Application No: FP/55/22/HH
Site Address: 7 Lindsey Court Felpham PO22 8JQ
Description of works: Erection of self contained annexe in rear.

Thank you for your internet representation made on 9th May 2022 which has been recorded as no objection with the comments as follows:

**7 Lindsey Court
Appendix 5 - development proposal plan**

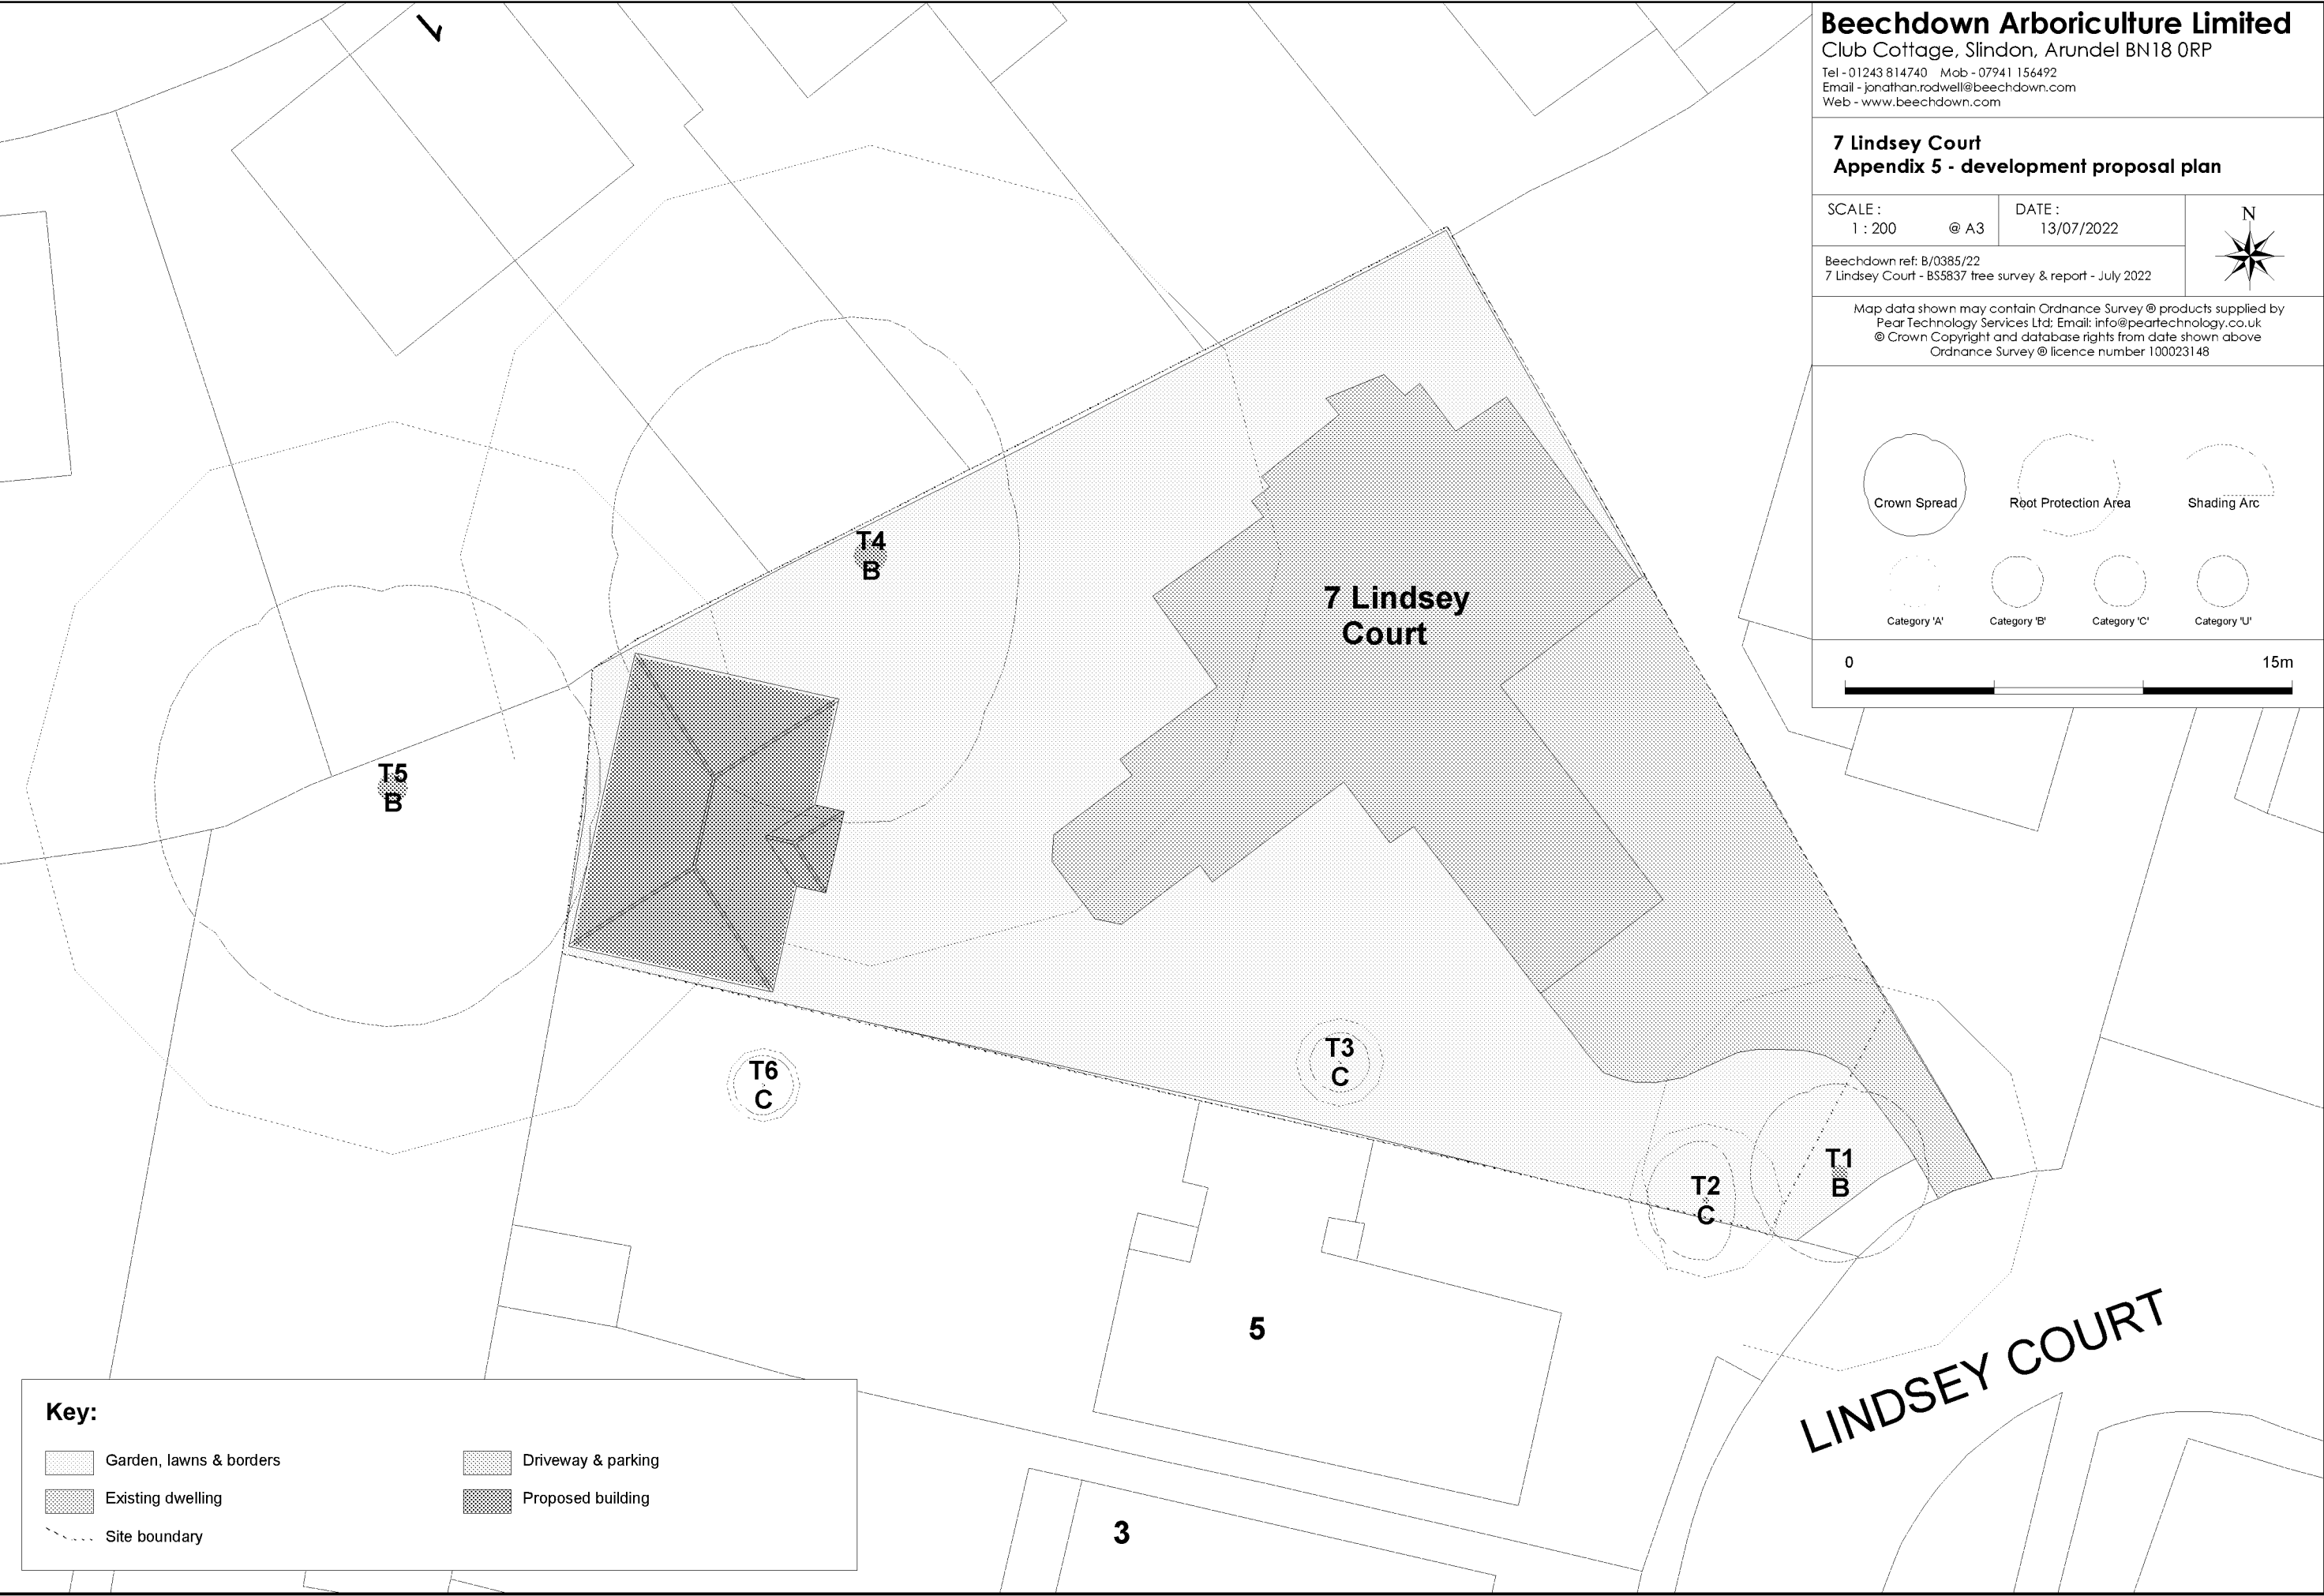
1. The plan does not show any trees near the proposed development although there are 2 large oak trees subject to TPO adjacent to the build location.
2. The proposed plan and elevation has no dimensions or scale shown so no sense of size

- 3 On the application form there is a section relating to Trees and Hedges. The specific question is "a-Are there any trees or hedges on the property or adjoining property which are within falling distance of the proposed development?" The application says NO. This is obviously a false statement as there are 2 very large mature Oak trees within a short distance of the proposed development. One, in my garden, is perhaps 30 feet from the site and the other in the applicants garden is about 10 feet away. Both trees are subject to TPOs and their canopies cover the whole area of the proposed build. Obviously both are within falling distance.
